Subject: **Hong/Kao Residence Remodel/Addition and new Detached Accessory Dwelling Unit
5425 W Mercer Way
Permit No. 2306-124**
Quantum Project #23127.01

We have received the correction notice on the above-referenced project dated 9/23/2023. Below are our responses to the structural comments. All changes to the drawings due to a plan check comment have been clouded on the drawings.

FOUNDATION PLAN
 1/4" = 1'-0" (E) - EXISTING

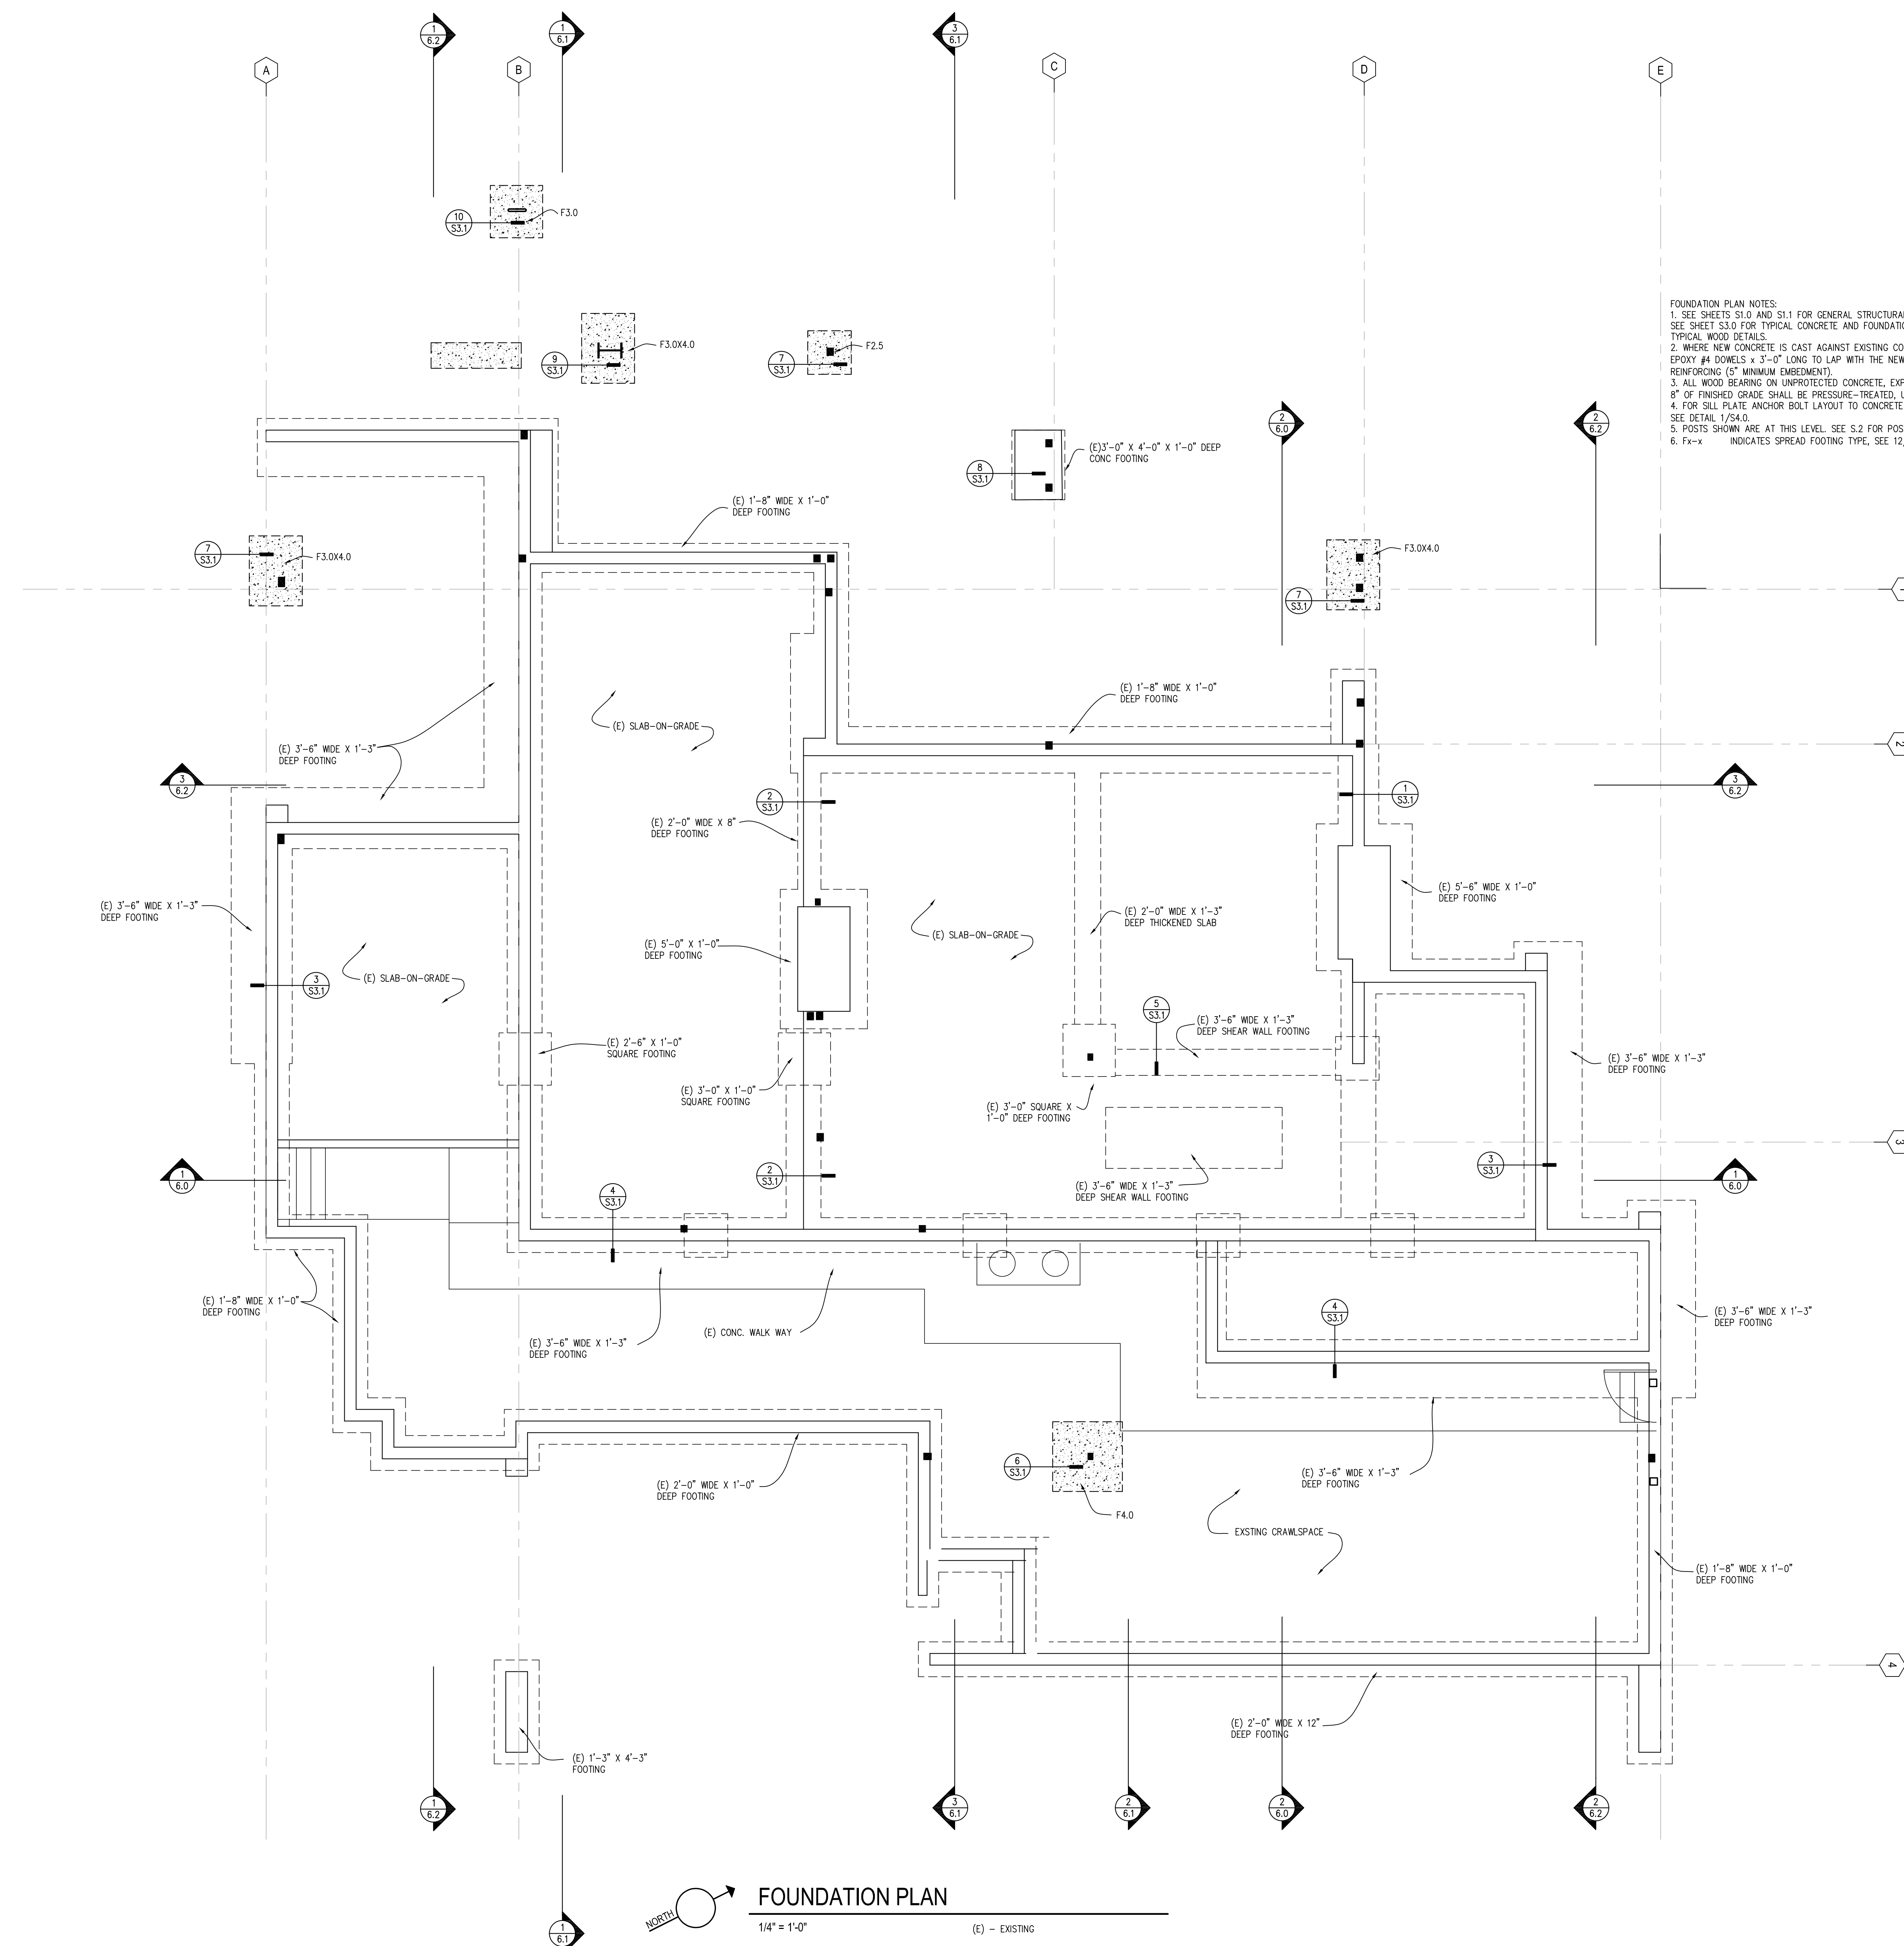
1. The framing plans on Sheets S.2 – S.4 are stamped by the engineer of record, but the Foundation Plan, Sheet S.1, is not. Please stamp the Foundation Plan since it contains important structural information.

Please see the revised sheet S.1 for the requested stamp.

MAIN FLOOR FRAMING PLAN

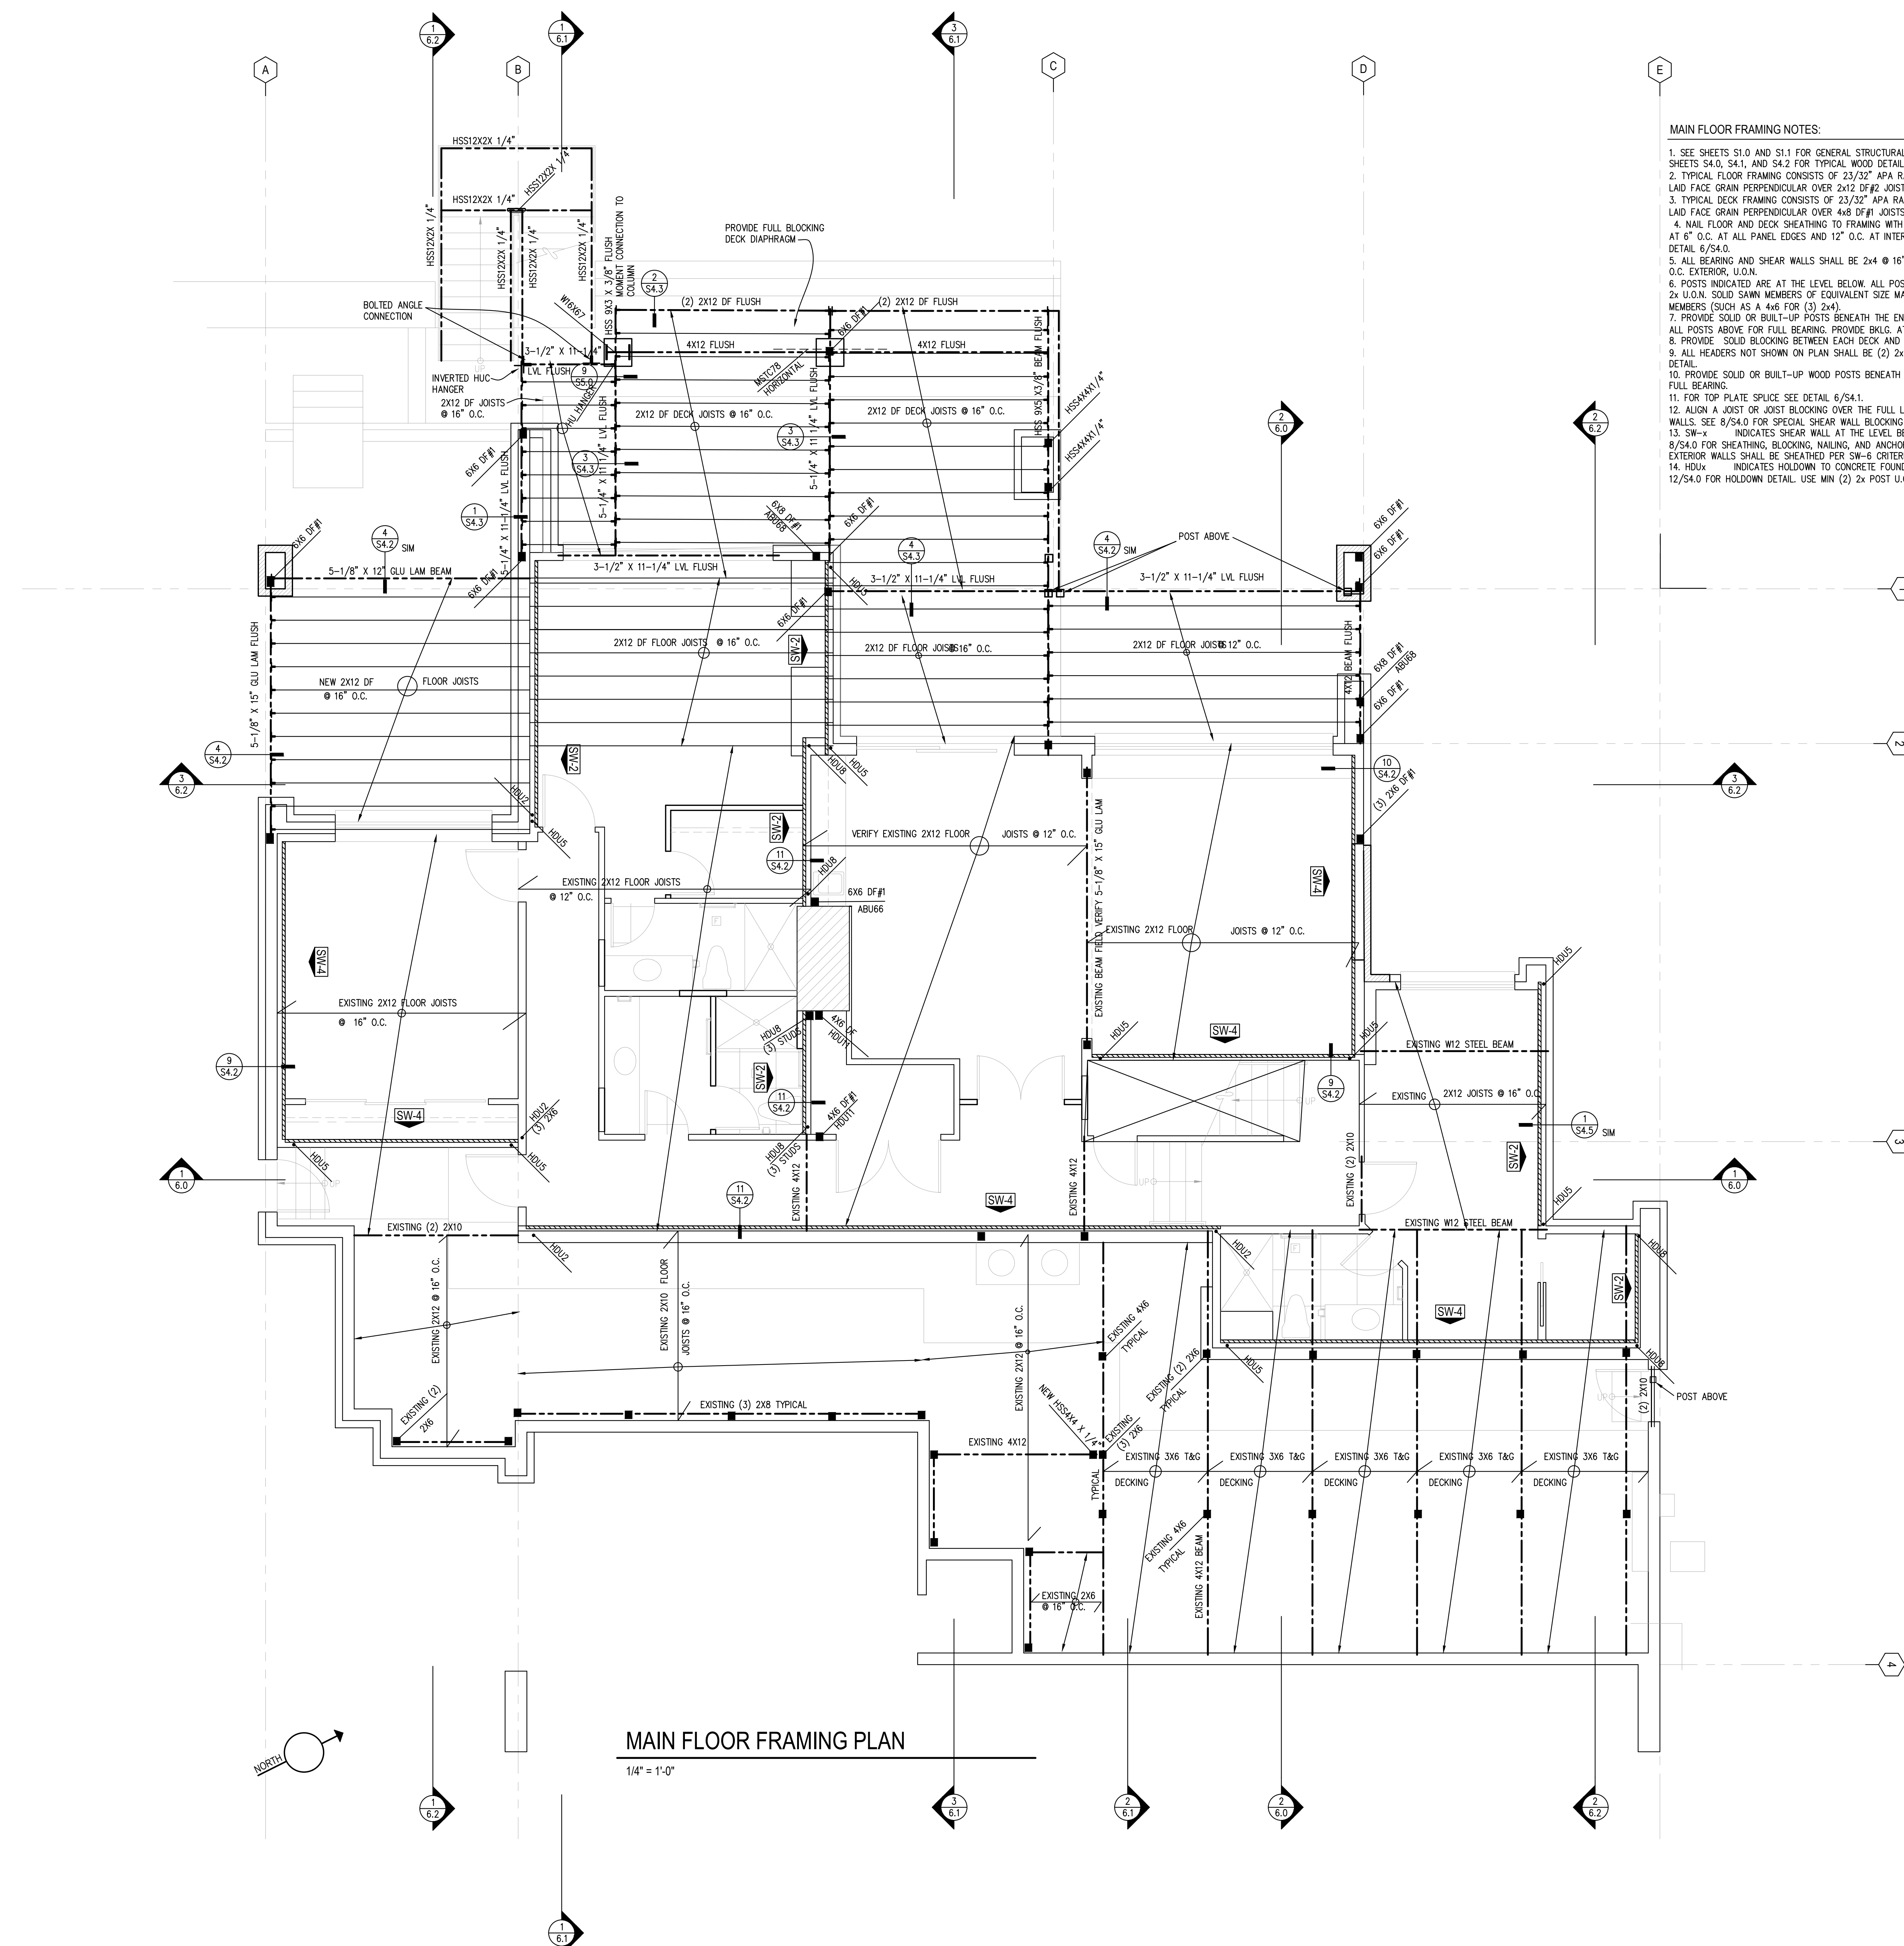
12. We are not finding the calculations for the 2x12 deck joists on the Main Floor Framing Plan, Sheet S.2. Please clarify where those are evaluated.

Note that the originally submitted Joist J1 calculations on page 36 show the design for the main floor deck joist. This page is included in the supplemental calculations for reference.
